November 19th 2021

Re: 21/01224/OUT Outline planning application for Automotive Experience Quarter comprising Commercial, Business and Services uses (Class E), Light Industrial (Class B2), Local Community and Learning Uses (Class F) and vehicle circuits (Sui Generis)

Figure 45. Proposed Automotive Demonstration And Driver Experience Diagram (not to scale)

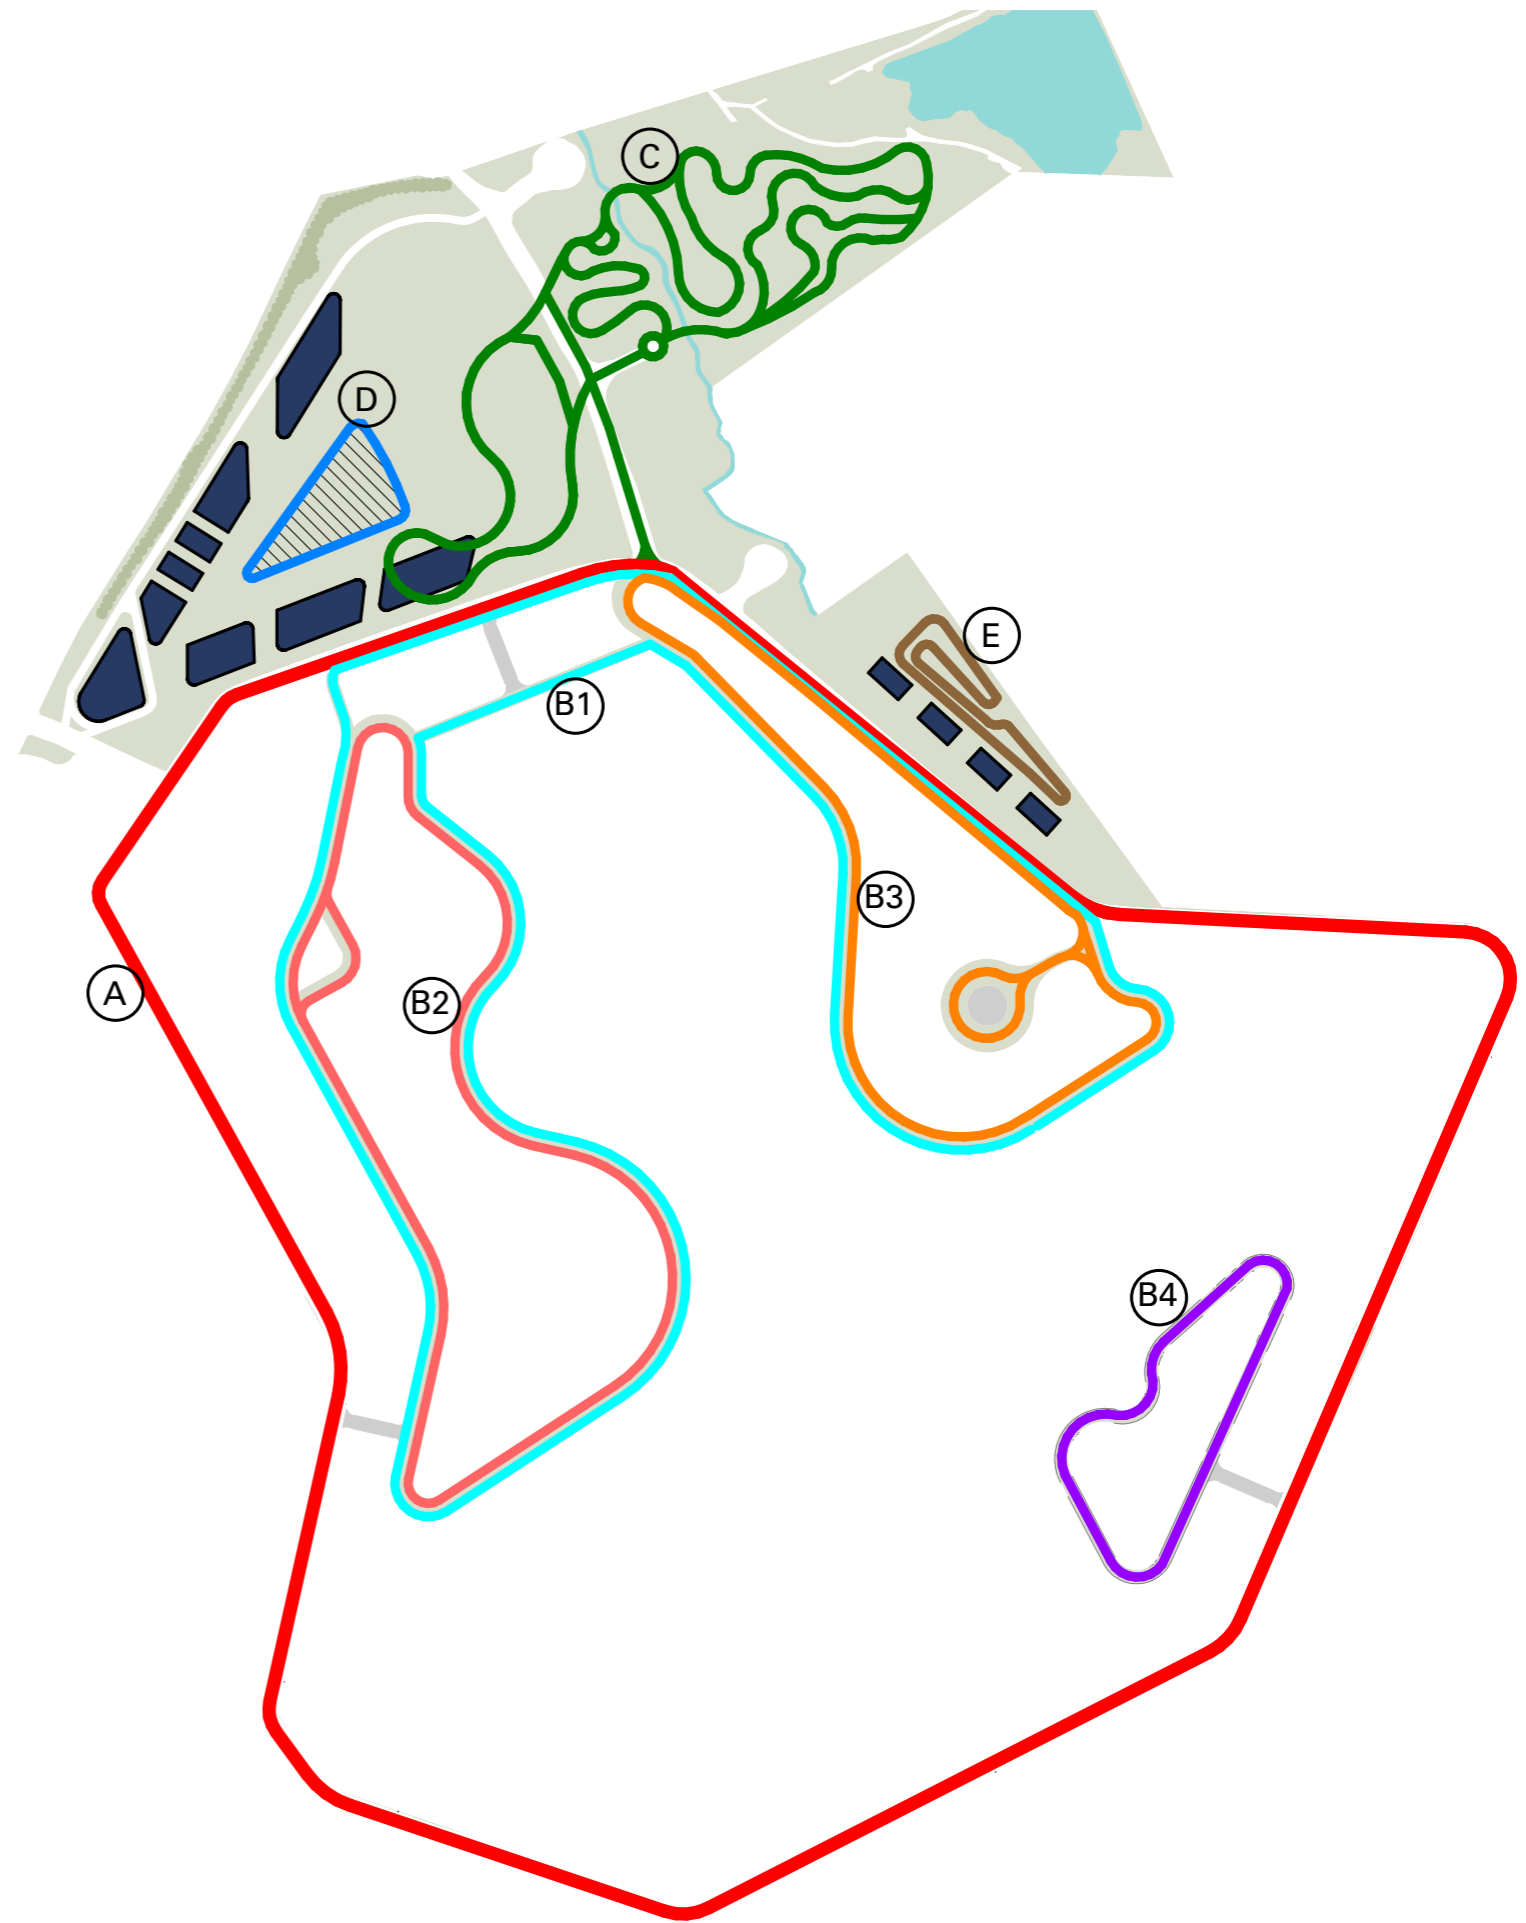
5. We note that an area in the north east of the site is marked as 'e-karting' on the indicative layout plan where previously there were to be 'viewing pavilions'. CPRE questions whether details of this update are given and also included in the biodiversity assessment, such as the area this would cover and what kind of surface is intended.
